Phone: 0300 123 6780
Email: developeras@lancashire.gov.uk
Your ref: 3/2025/0067
Our ref: 3/2025/0067/HDC/KW
Date: 20 April 2026

Location: Shaw House Farm Clitheroe Road Whalley BB7 9AD
Proposal: Change of use of land from an equestrian field (sui generis) to a dog exercise area (sui generis) including retrospective consent for an existing mesh fencing boundary treatment.
Grid Ref: 373209 437322

5563 - P01D

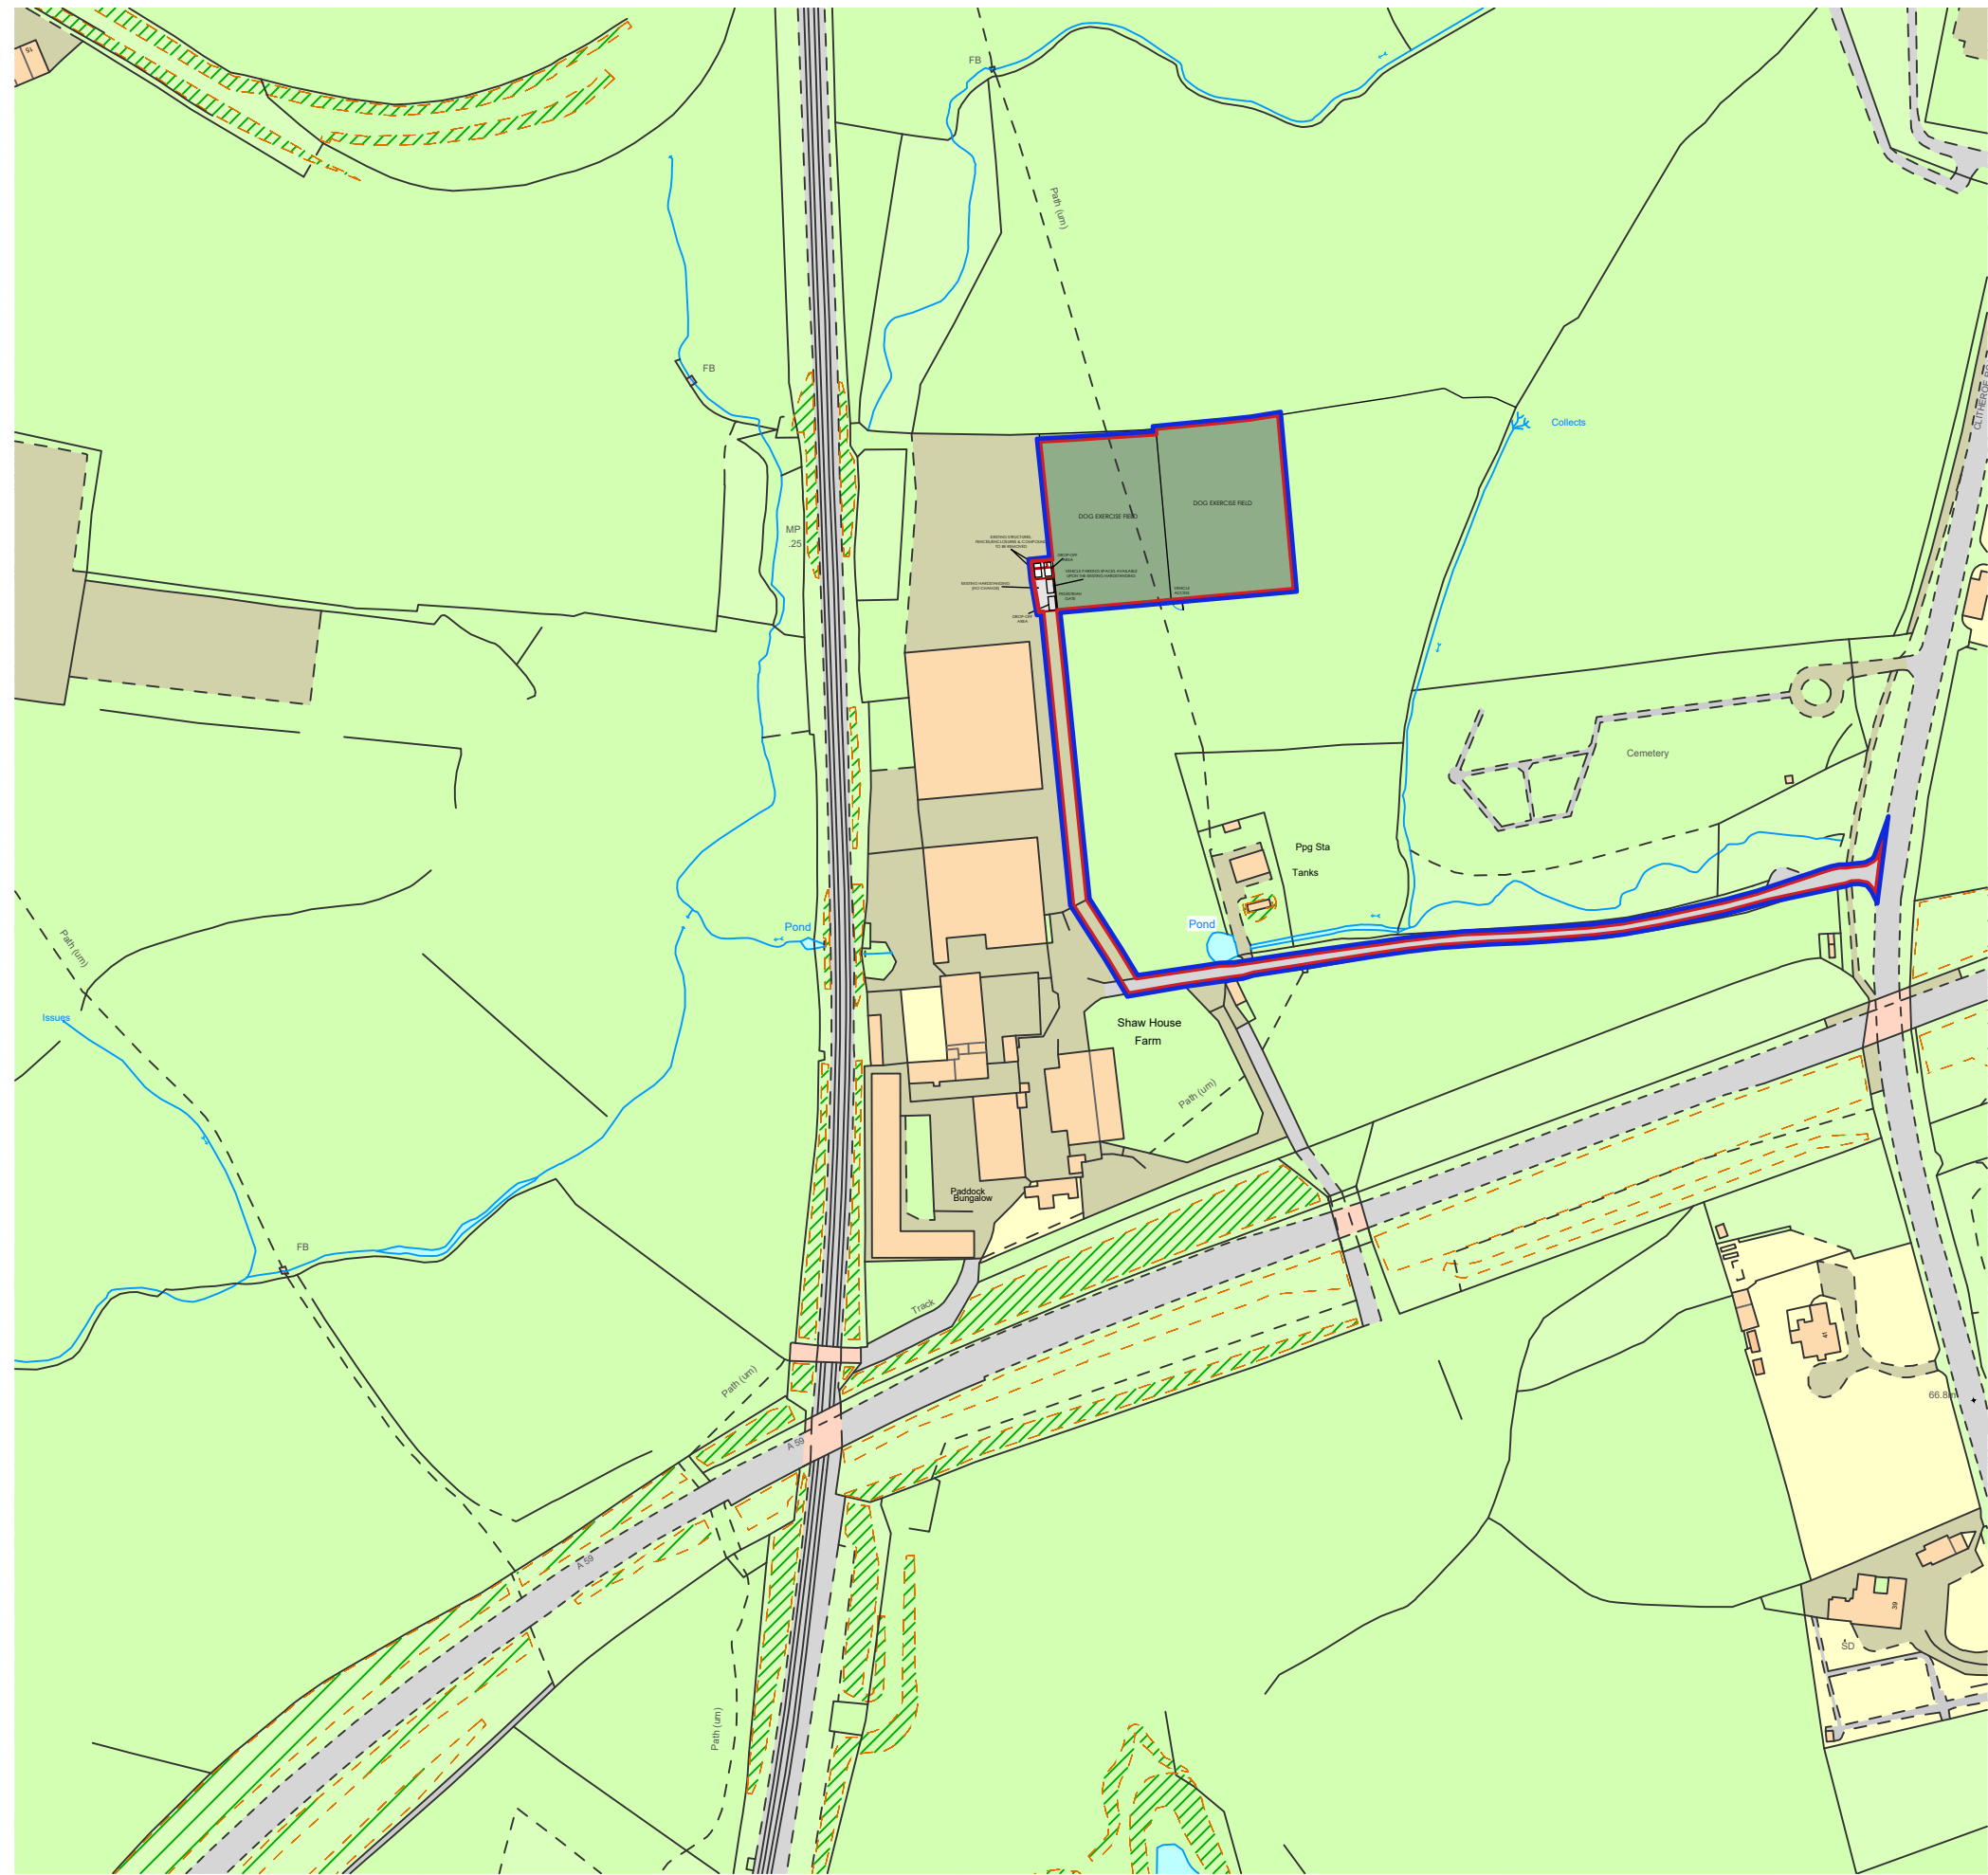
The LHA have reviewed drawing number 5563 P02D titled "Proposed Site Plan" and are aware that four parking space can be provided within an existing hardstanding area which would meet the demands for the site, considering the information provided within the operating statement.

2. The parking spaces hereby approved, as shown within drawing number 5563 P02D shall be kept available for use by staff and operational vehicles at all times. These spaces shall not be used for storage or any purpose that would prevent their use for parking.
